OUT20/6406

**Bowden's Silver Project (SSD 5765)
Environmental Impact Statement**

Mitchell Isaacs
Director, Office of the Deputy and Strategic Relations
Department of Planning, Industry and Environment: Water
31 August 2020

**Bowden's Silver Project (SSD 5765)
EIS
Detailed Information**

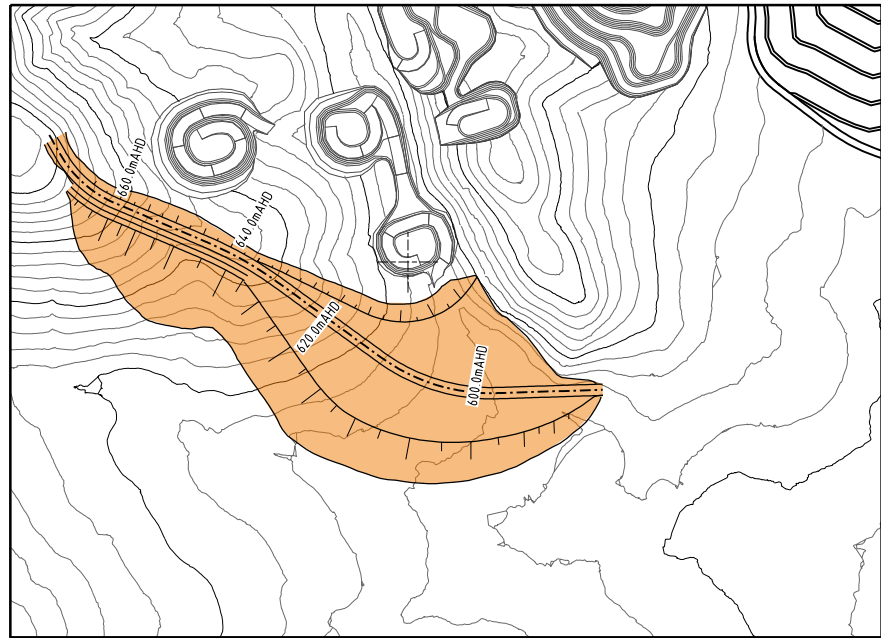
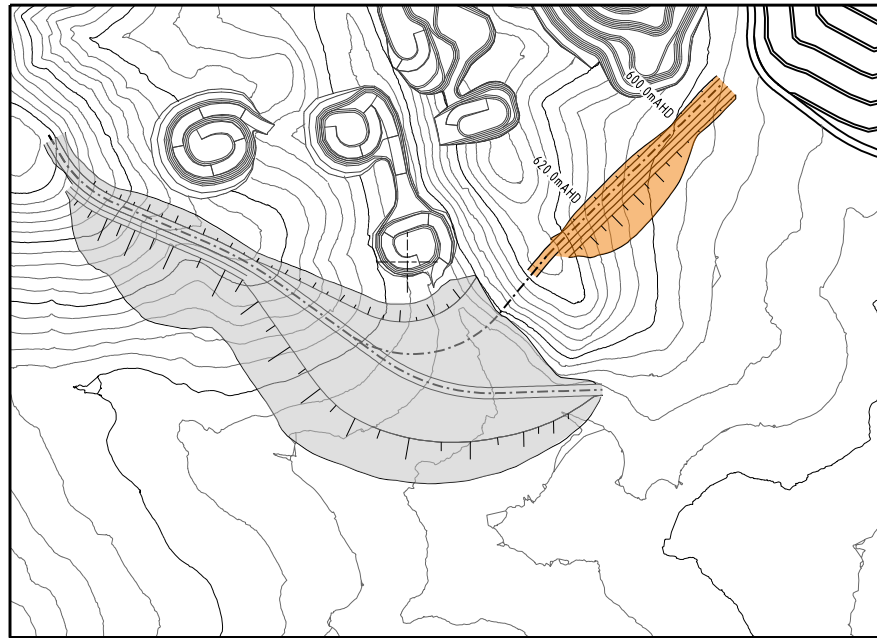
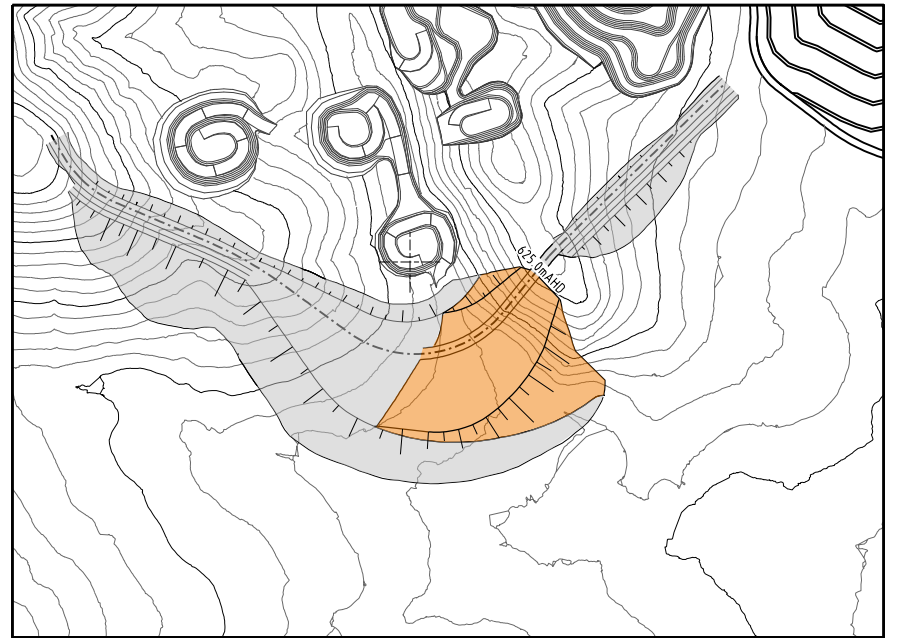
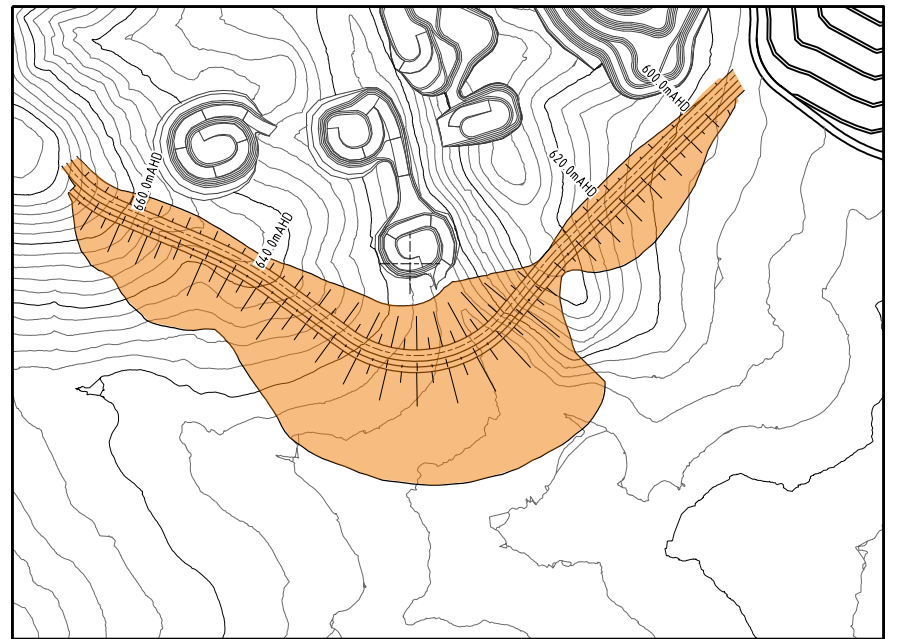
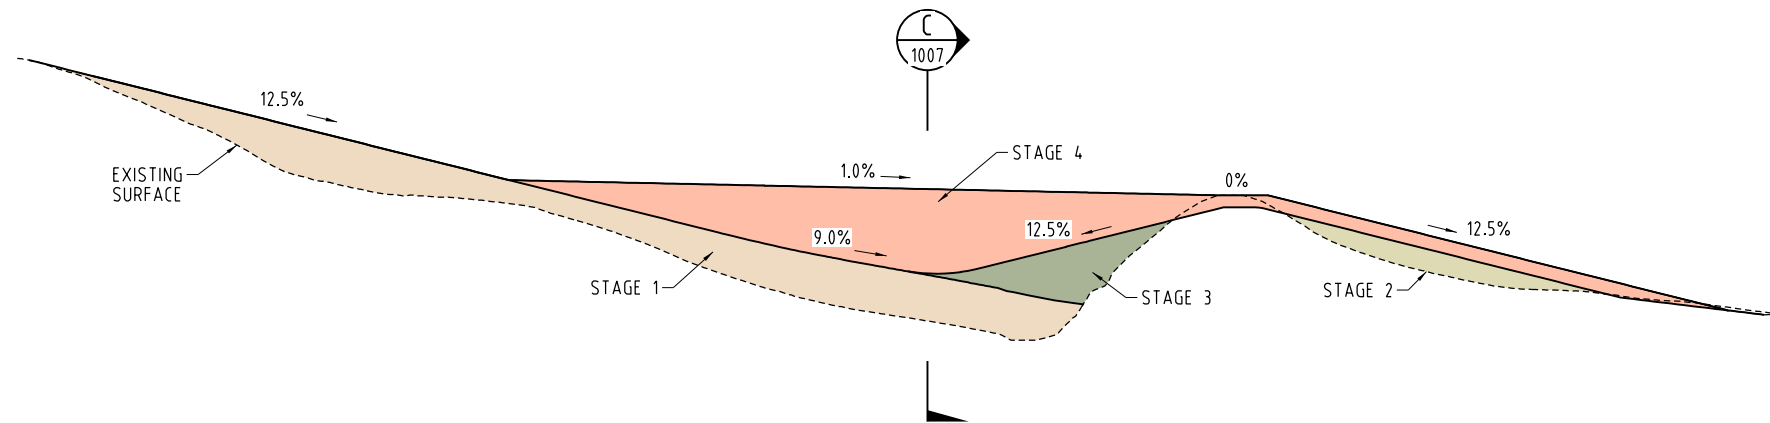
- The Southern Barrier is to be constructed temporarily across Blackmans Gully, a third order watercourse for the project life. A pipe/culvert is proposed to be constructed under the barrier to maintain the flow of Blackmans Gully. Based on the ability of this pipe/culvert to adequately convey the flows through the barrier no licensed entitlement will be required.

The temporary Southern Barrier will be constructed over Blackmans Gully which is a third order watercourse. The discharge capacity of the proposed pipe/culvert under the barrier has not been quantified, hence it is not clear of its adequacy to convey the catchment runoff volumes downstream and any potential impacts to flow.
